From: Simon Davis
Sent: 23 February 2018 11:29
To: 'Peter Champion'
Subject: RE: BR/48/18/PL Brodrick, 1 Castle Close

Title
PROPOSED ELEVATIONS

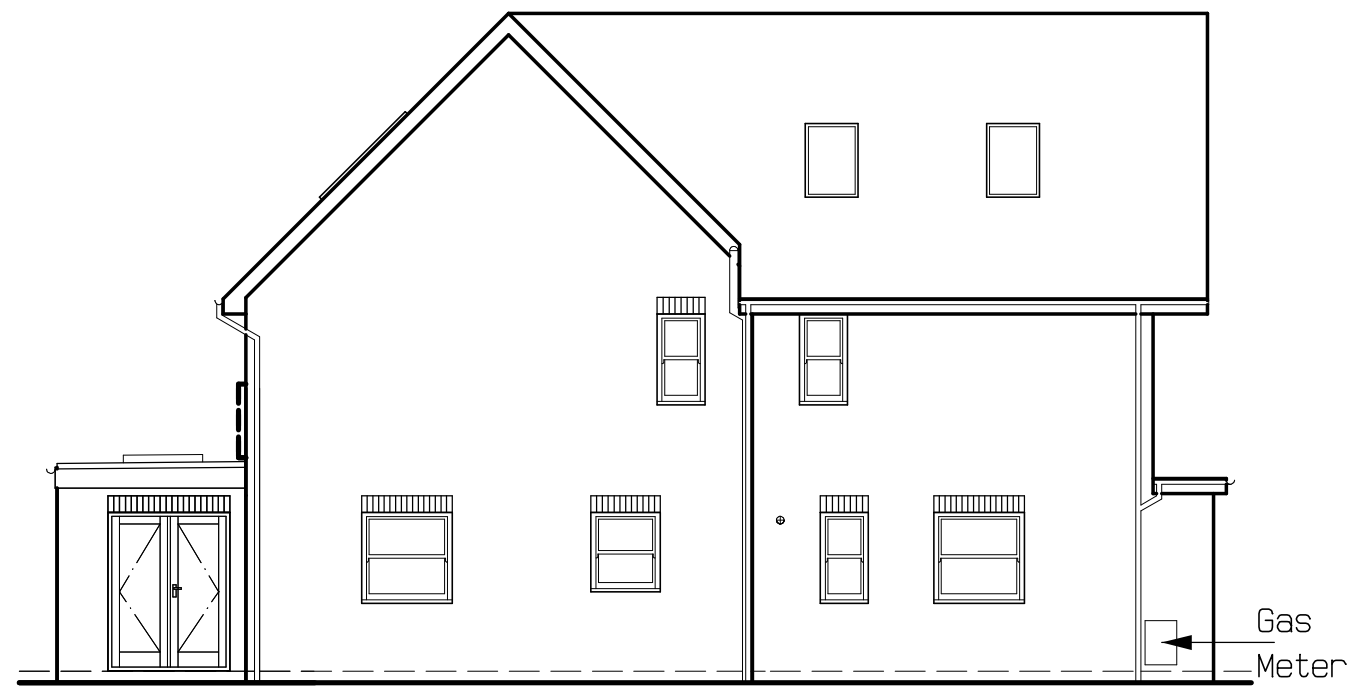
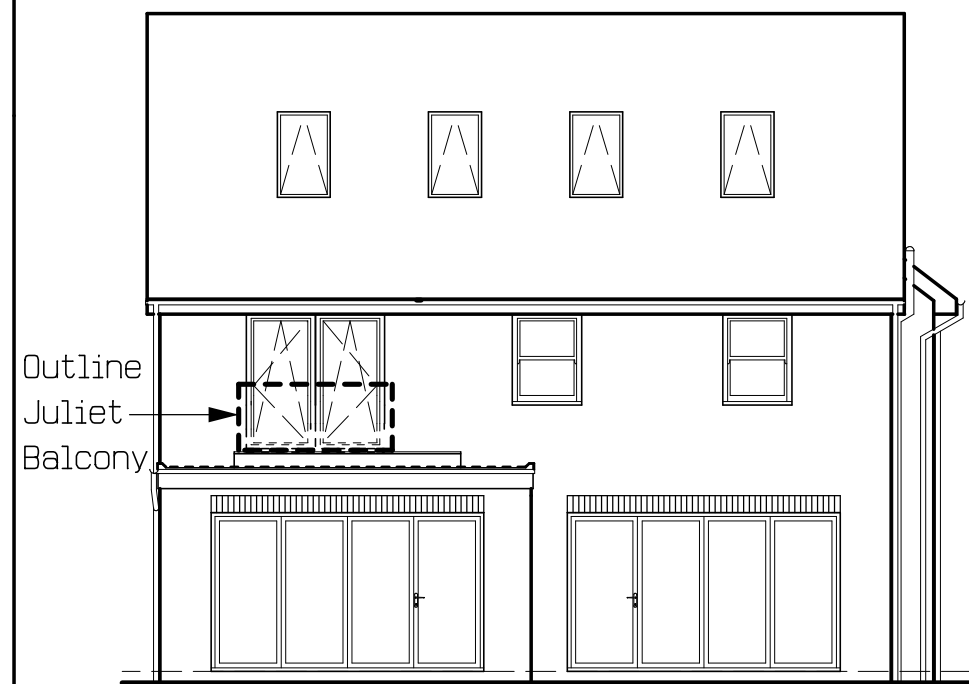
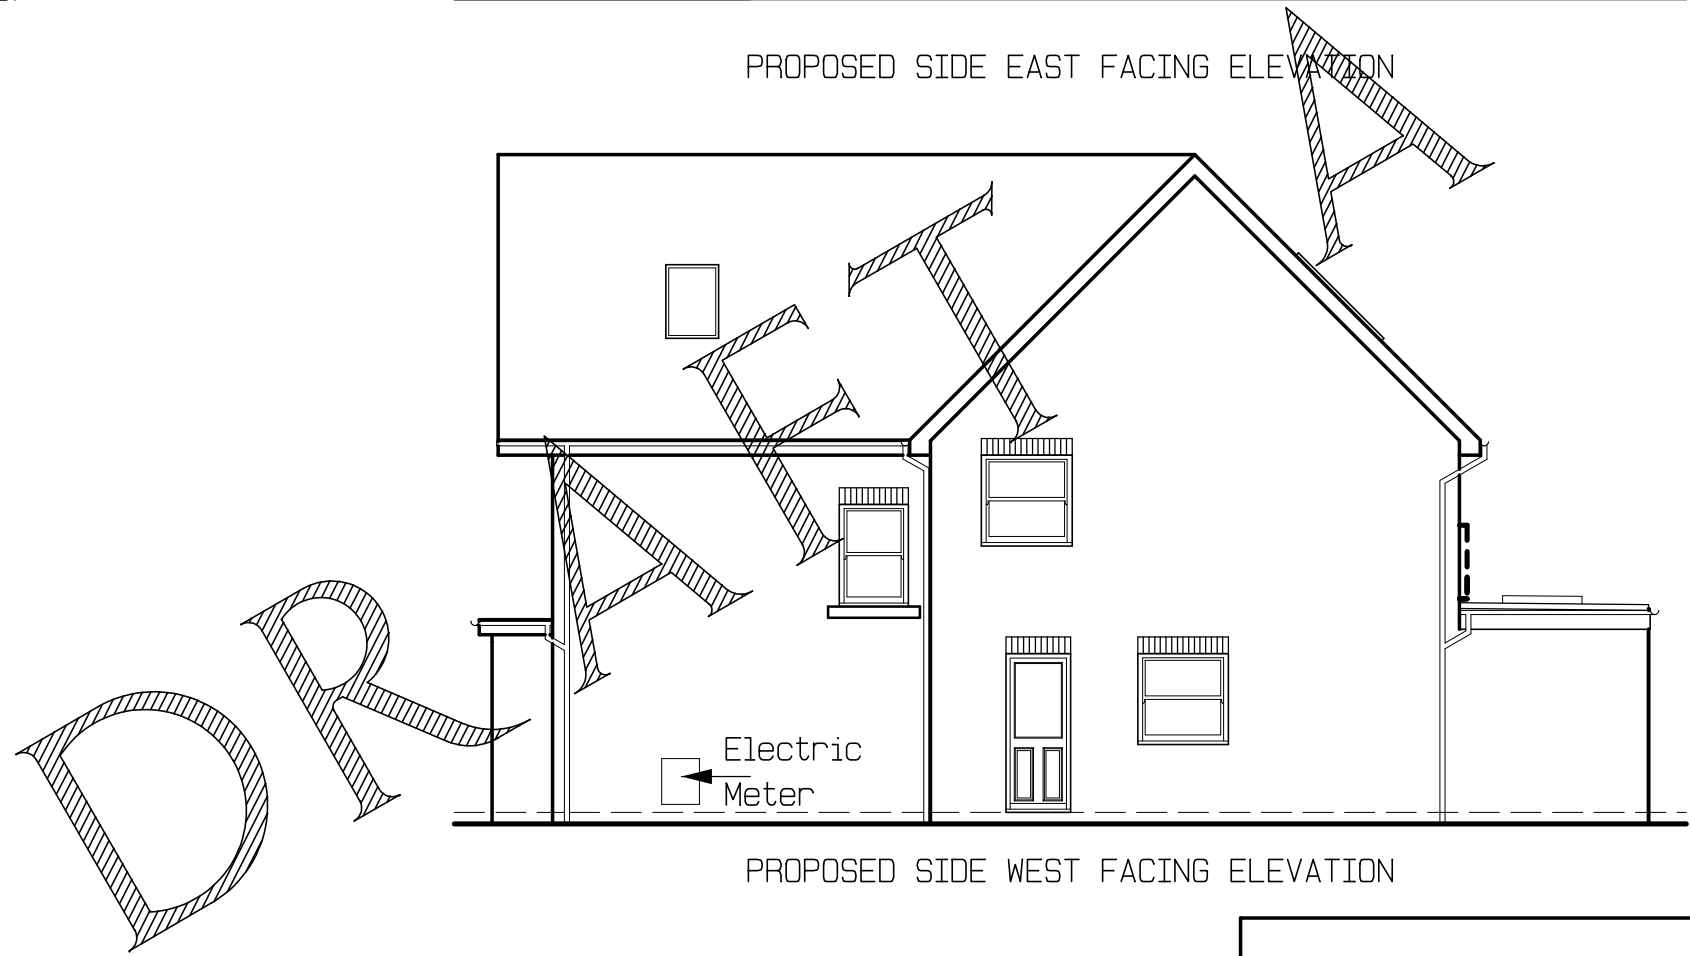
I see that the proposal adds windows to the roof. Is this to create additional accommodation within the roof? If so, this needs to be within the description and we would need new floorplan as the current permissions are for a dwelling with ground and first floors only.

Ok. I have agreed with my Team Leader that we don't need a floorplan. However, I will reference this on the development description.

My recent Non-Material Amendment, BR/314/17/NMA, for the hip-to-gable change at the front, included as its reason, *"To improve appearance, but mainly to form useful loft space"*. It will be a large storage area, and not subdivided, although of course it may be that future occupants may choose to do so. If you wish me to provide a floor plan I can do so, but it will be simply one large space, with access of course.
I hope this helps.
